### **MEMORANDUM**

TO: All Staff  
FROM: Justin Turnbull, County Surveyor   
DATE: October 22, 2021  
SUBJECT: County Survey Review of BL-20-00018 Whitman

WHITMAN P

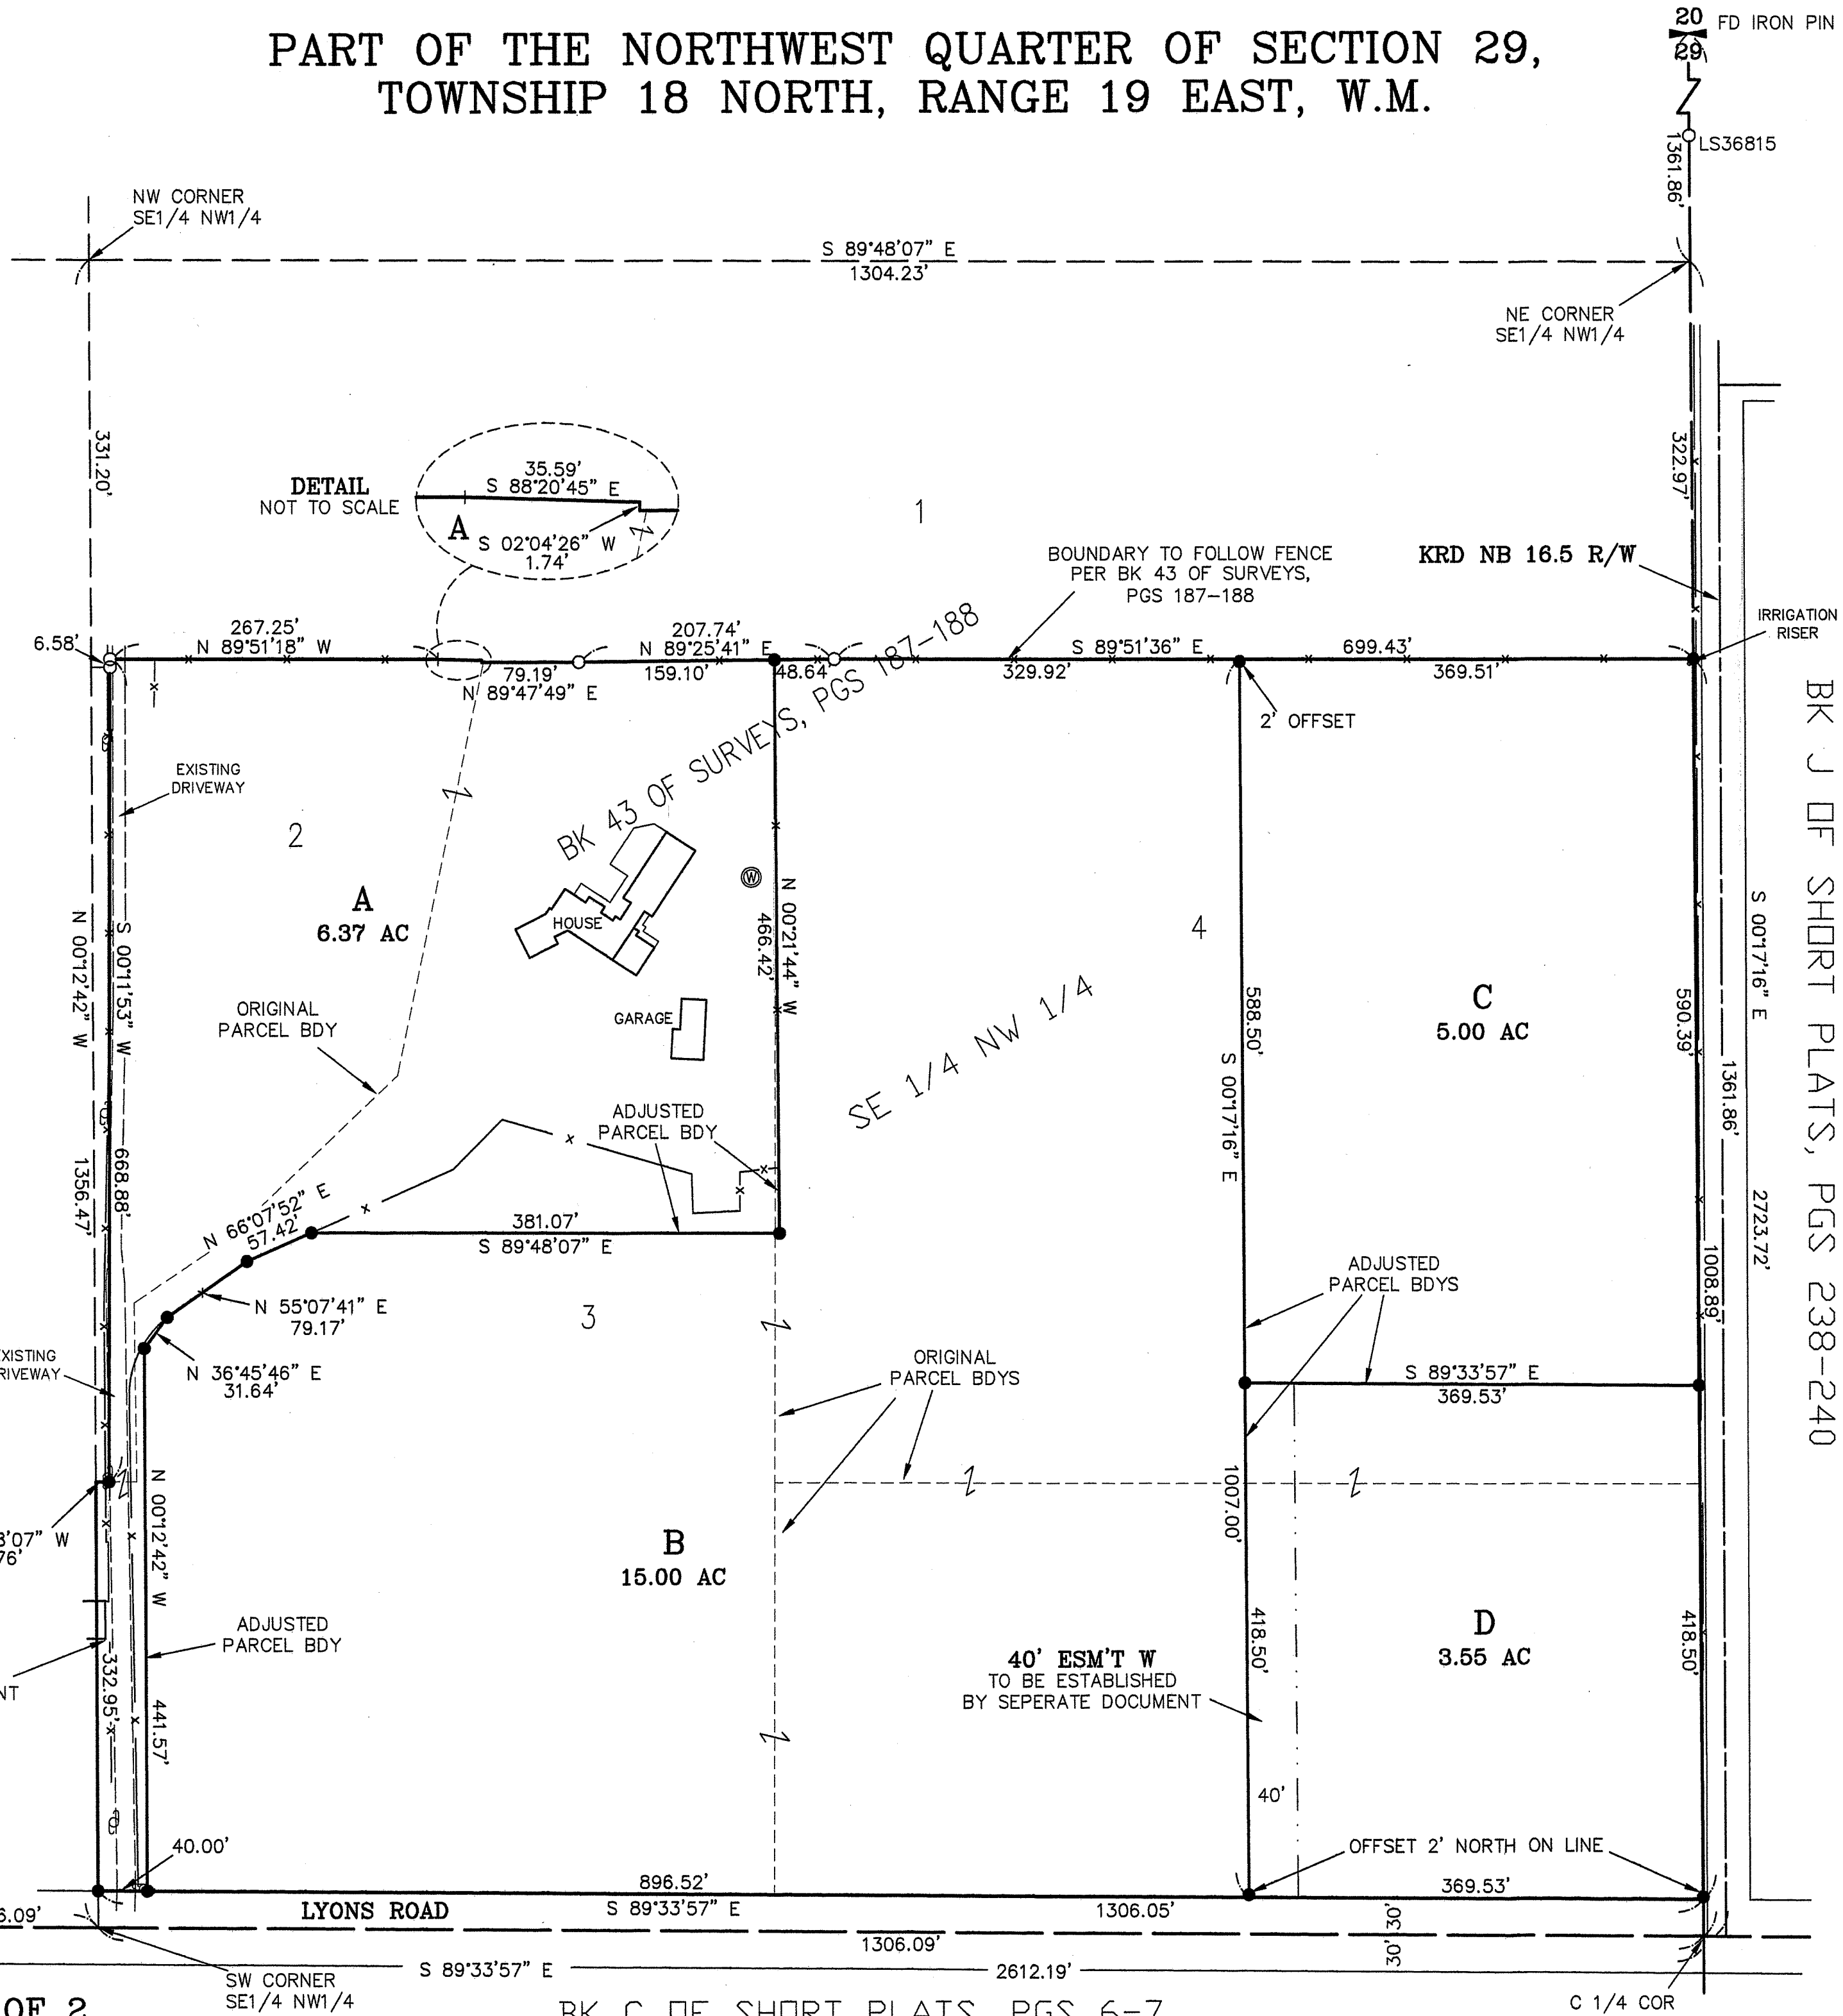
1. Please include the ownership/type and surfacing for Lyons Rd. EX: 60' County R/W-Paved).
2. Please label Rosebriar Lane (Private-paved).
3. If the found corner located north of the project, south of the N1/4 corner was used as survey control, it should include suitable ties to locate said corner.
